Application Ref:	3/2025/0435			 Ribble Valley Borough Council <small>www.ribblevalley.gov.uk</small>
Date Inspected:	04/07/25	Site Notice:	N/A	
Officer:	LW			
DELEGATED ITEM FILE REPORT:				APPROVAL

Development Description:	Proposed two storey side extension and rear bay window.
Site Address/Location:	6 The Grove, Whalley, BB7 9RN.

Drawing Title
Existing Plans and Elevations

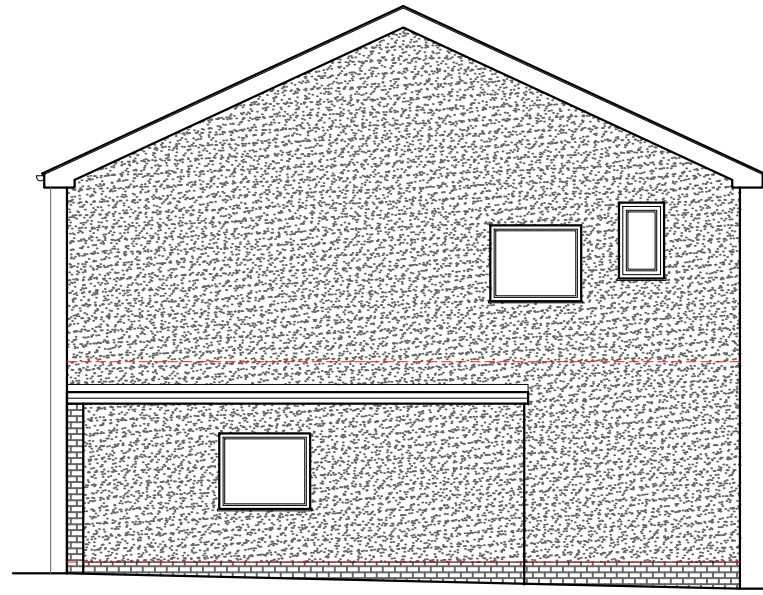
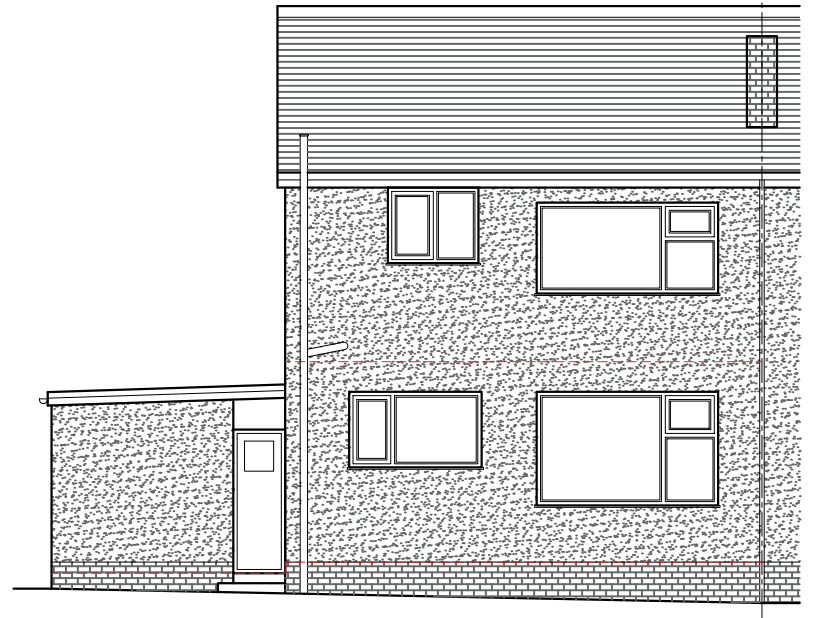
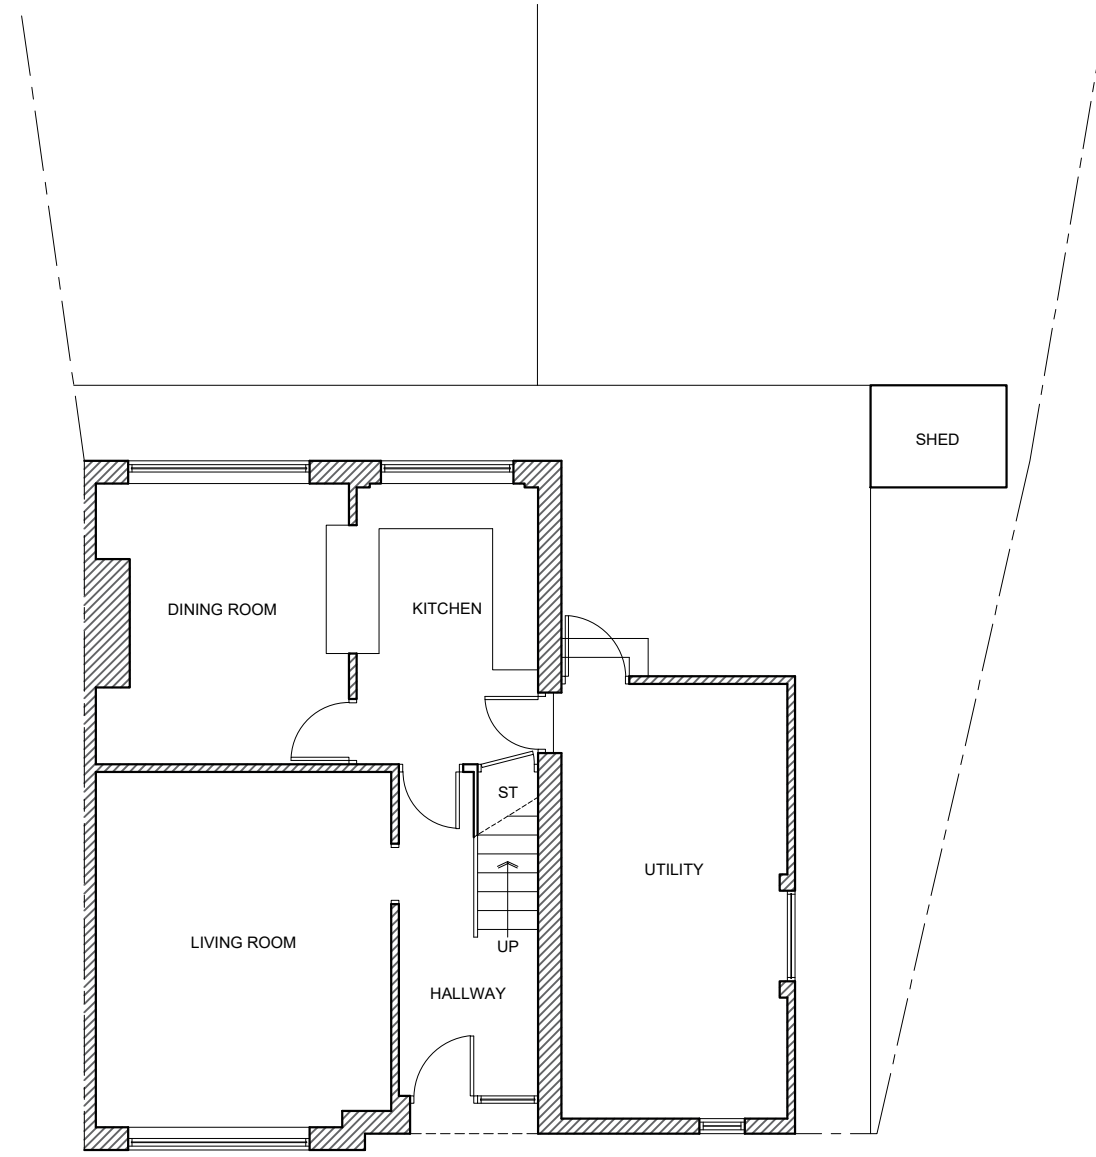
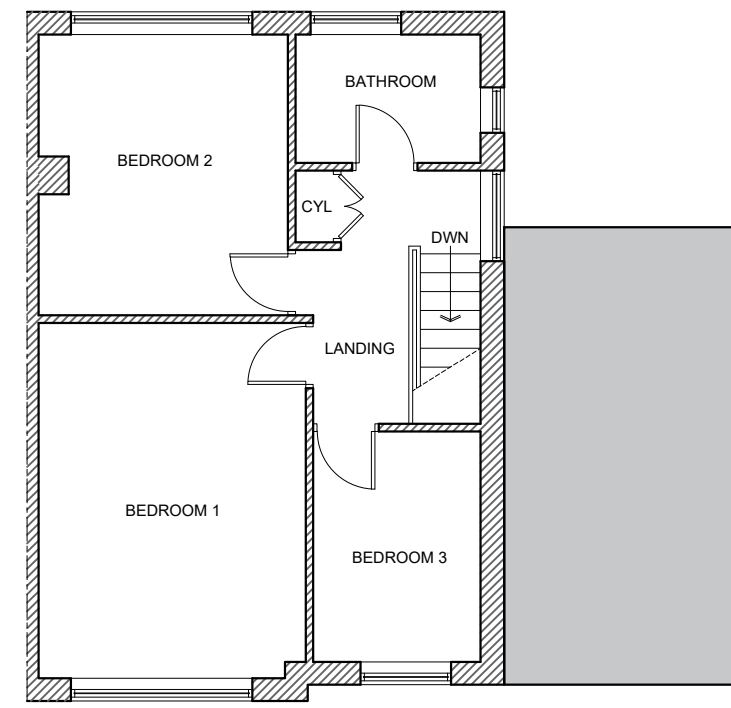
The application has been subject to review by Lancashire County Council Highways. In the consultation response received from the Local Highway Authority (LHA) dated 10th June 2025, it was noted that the proposal would result in the loss of a garage as shown on the submitted Existing and Proposed plans. However, the integral garage had already been converted into living accommodation several years prior to the submission of this application. The development the subject of this application would therefore not directly result in the loss of garage parking. The Existing plans have been updated to reflect this.

PROPOSED GROUND FLOOR PLAN SCALE 1:100

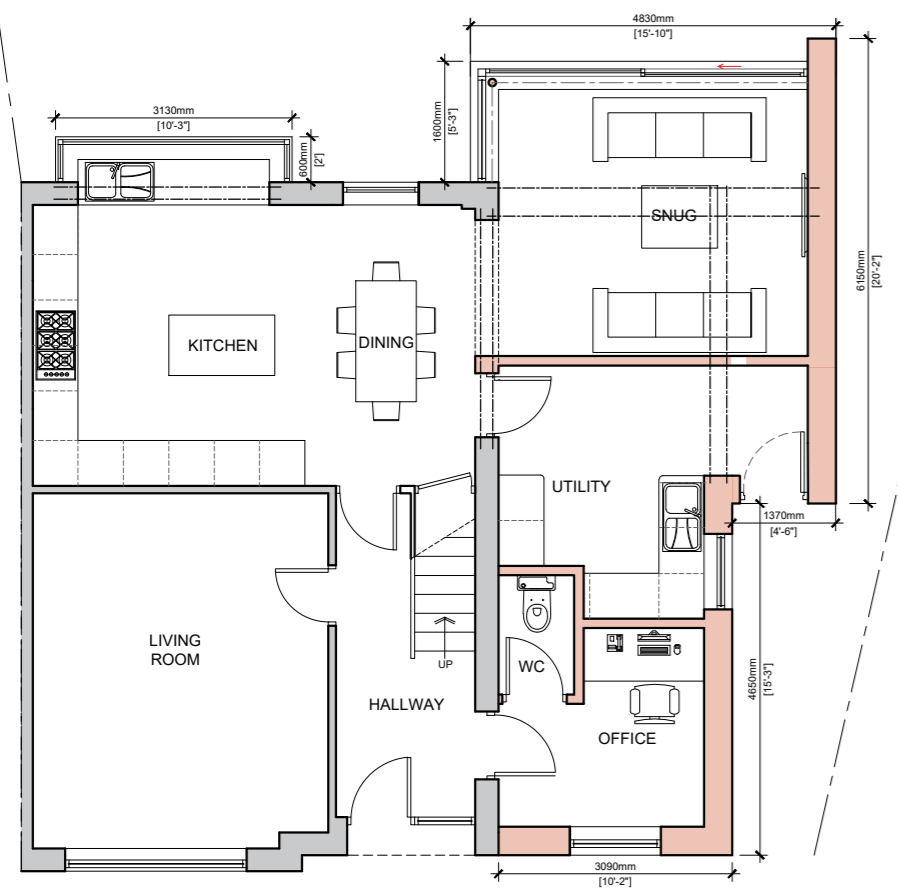
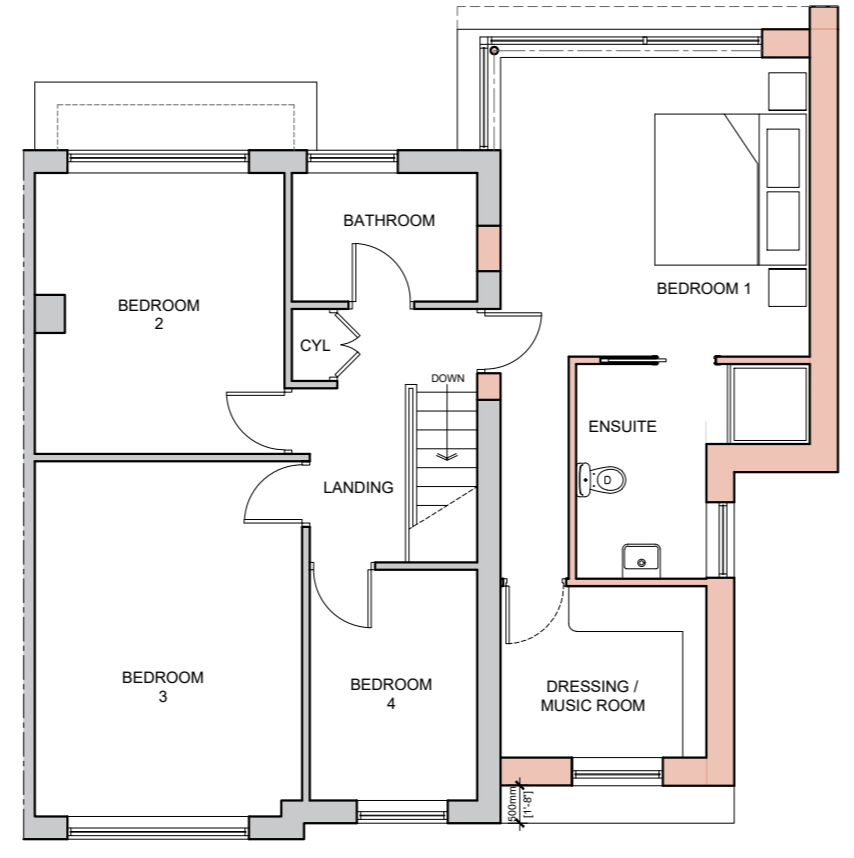
Notwithstanding this, the proposal would increase the property from a 3-bedroom dwelling to a 4-bedroom dwelling. As such, the LHA requested the submission of a parking plan showing that the three parking spaces required to meet parking standards for a four-bedroom dwelling could be accommodated within the proposal site.

A revised Proposed Site Plan has been submitted which shows that parking for three vehicles can be accommodated to the front of the property on the driveway. This amended plan has been reviewed by the LHA and subsequently no objections have been raised. As such, the proposed development is considered acceptable with respect to highway safety and parking.

PROPOSED NORTH WEST ELEVATION SCALE 1:100

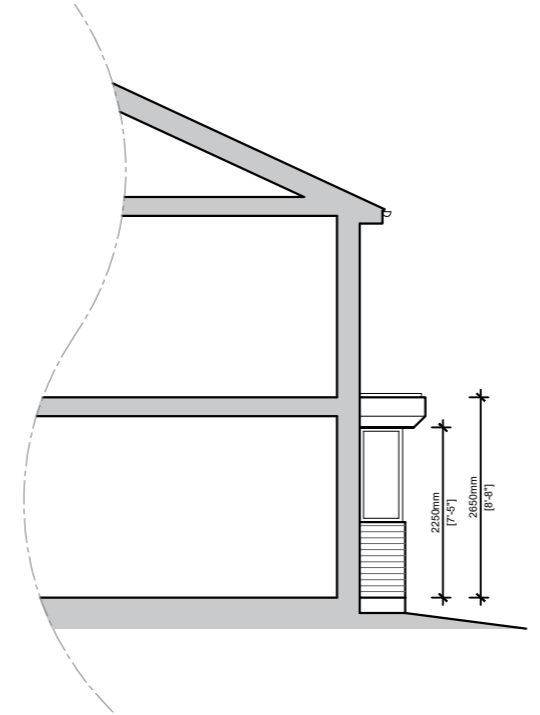
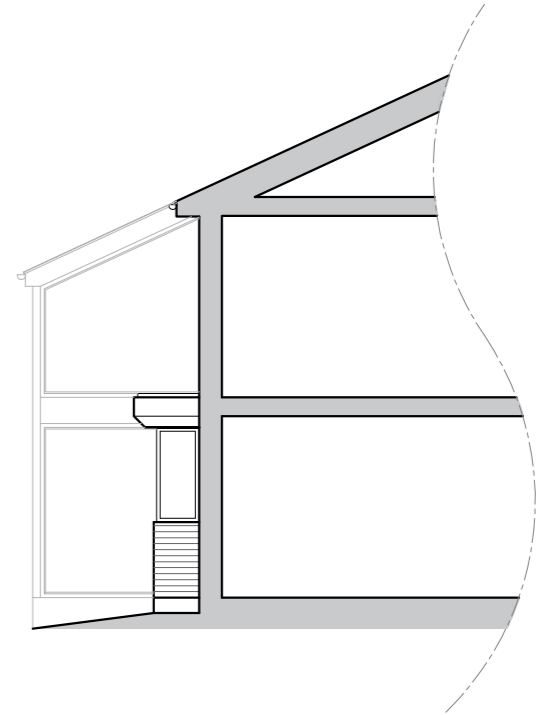
The glazing proposed to the south-eastern side elevation of the extension would provide views towards the private amenity space associated with No.8 The Grove, particularly given the lack of any solid boundary treatment marking the shared boundary between the pair of semi-detached properties. As such, it is also considered appropriate to impose a condition requiring these openings to be obscure glazed in order to protect the amenity of the No.8 The Grove.

Taking account of the above, the proposed development is considered acceptable with respect to impact upon residential amenity, subject to a condition requiring the windows to the north-western and south-eastern elevations of the two-storey extension to be obscure glazed.
